CITY OF ALBUQUERQUE

October 24, 2012

**Re: Desert Hills Healthcare
Grading and Drainage Plan,
Engineer's Stamp dated 10-4-12 (G11/D048)**

C4.1

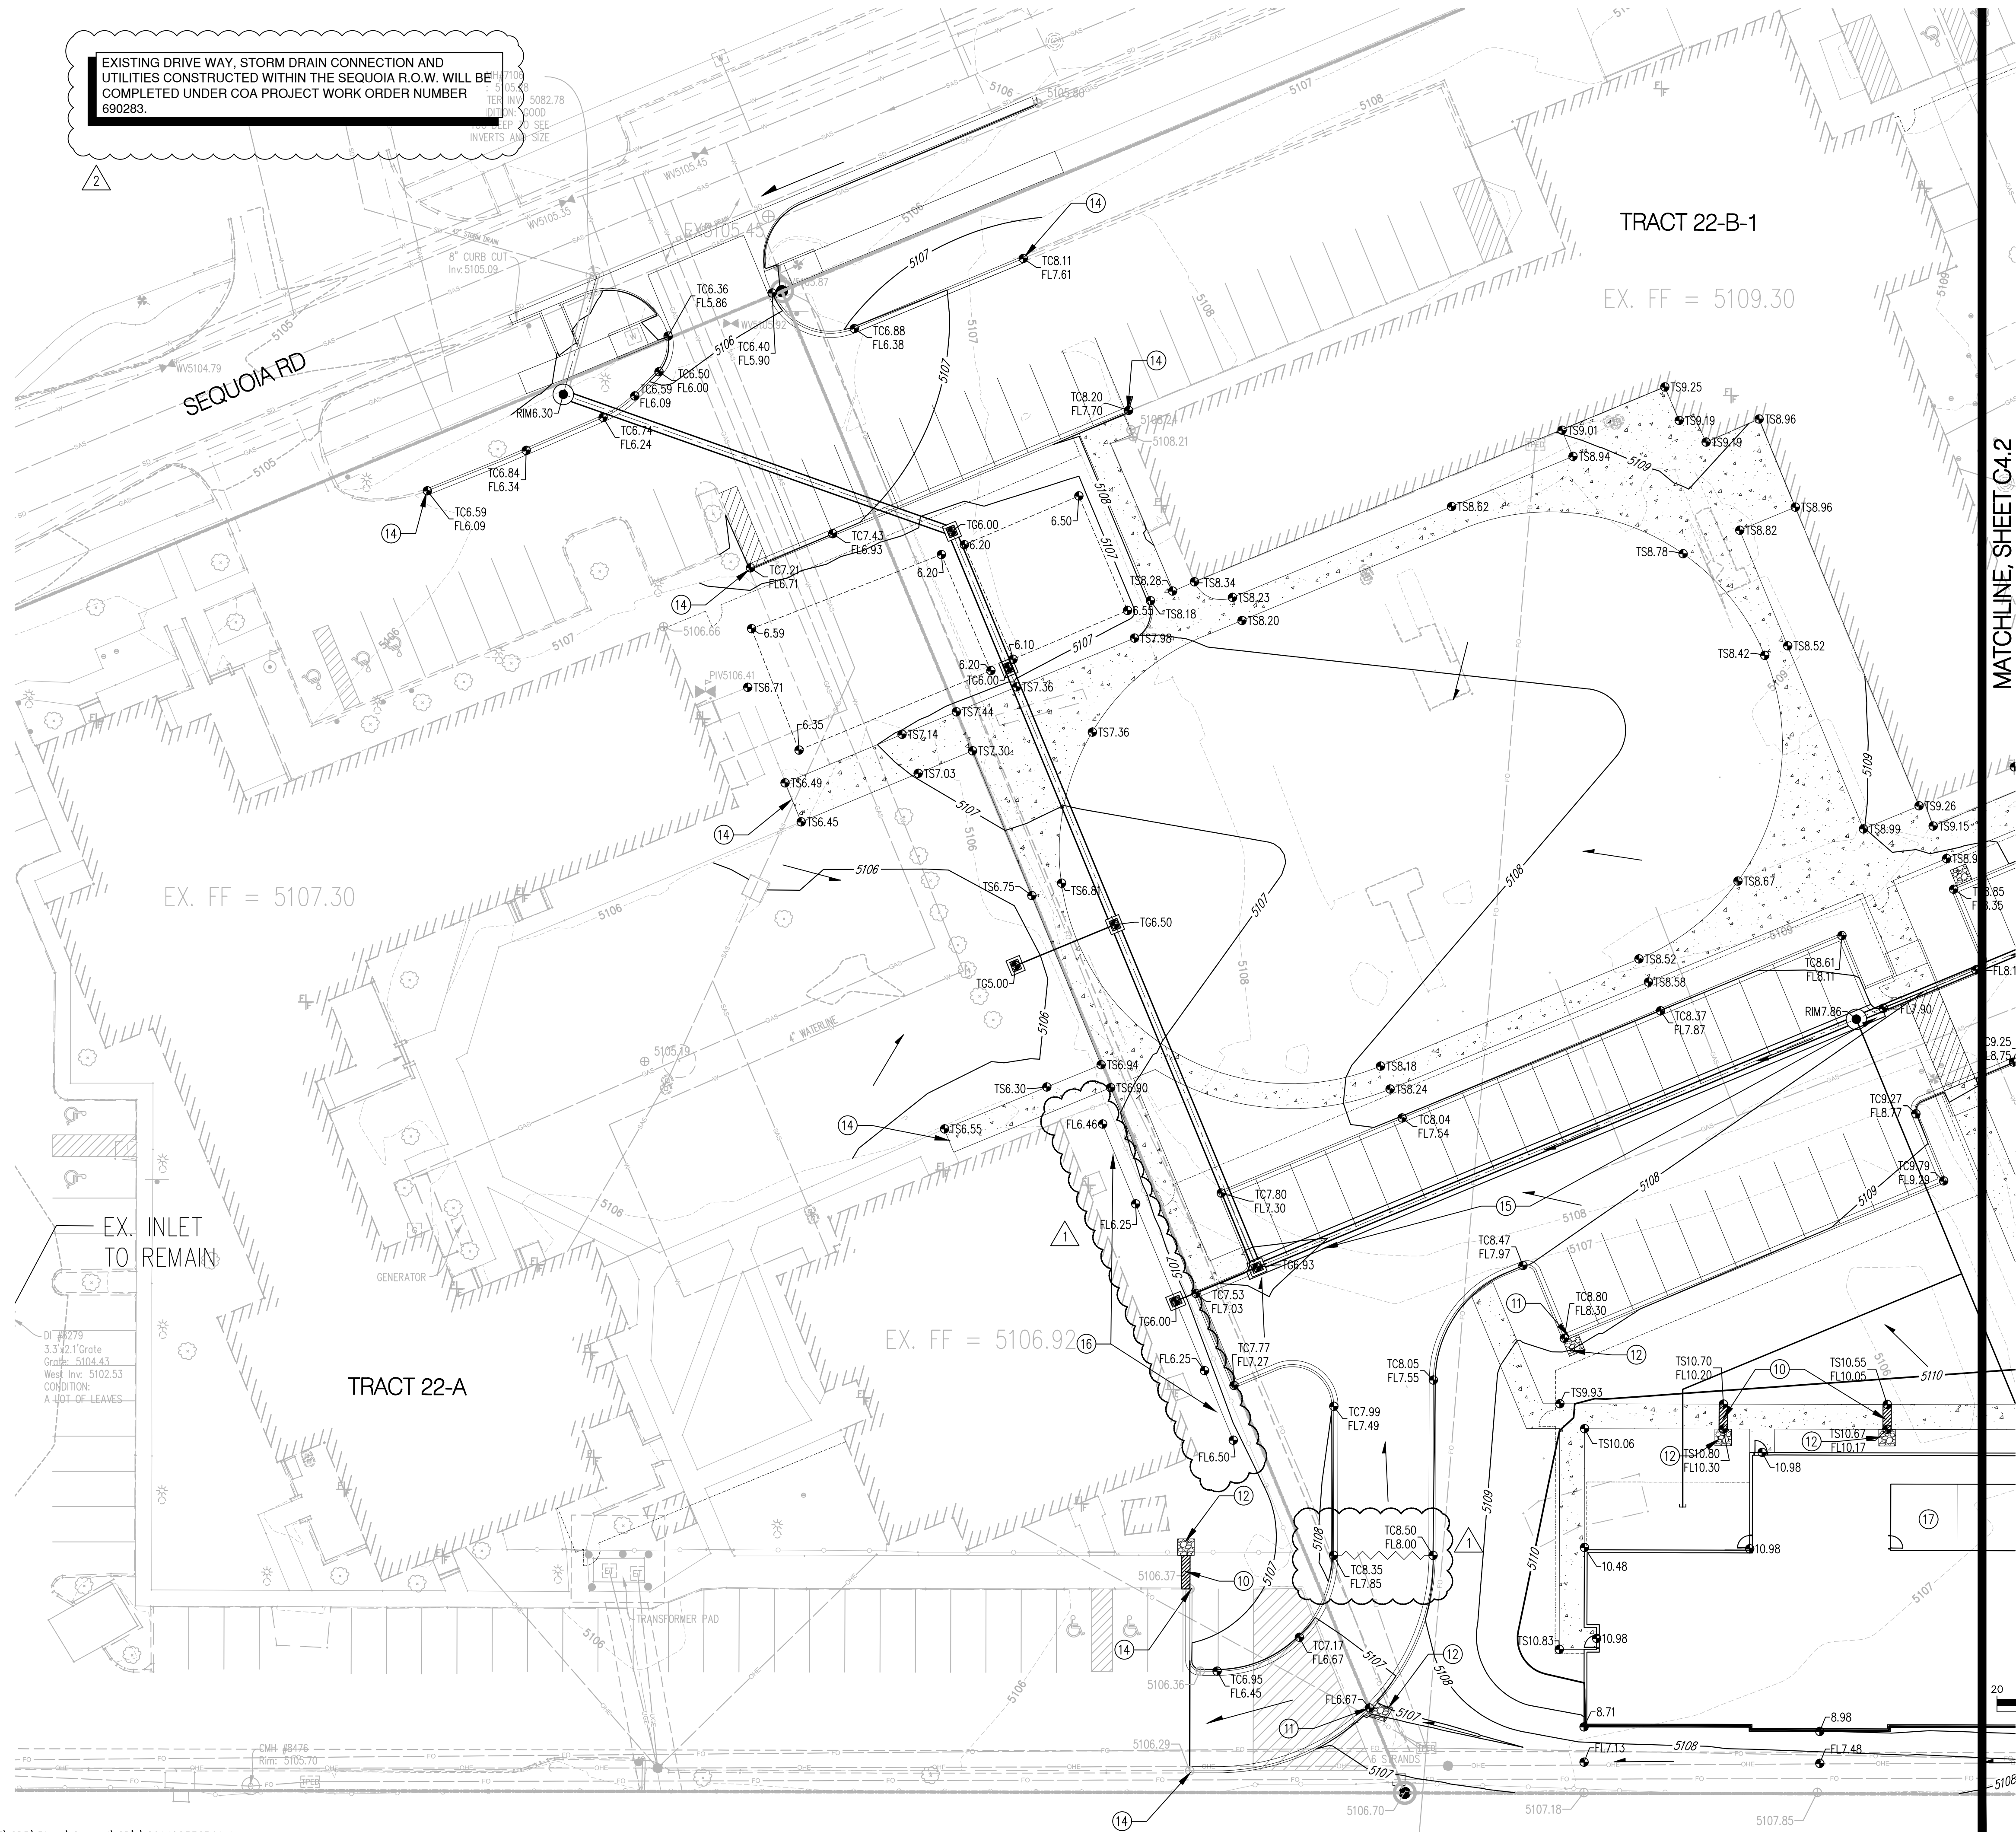
- The address given is 5310 Sequoia Rd. NW, but the site shown is 5200 Sequoia Rd NW. The address is incorrect, please clarify.
- Provide spot elevations around pond.
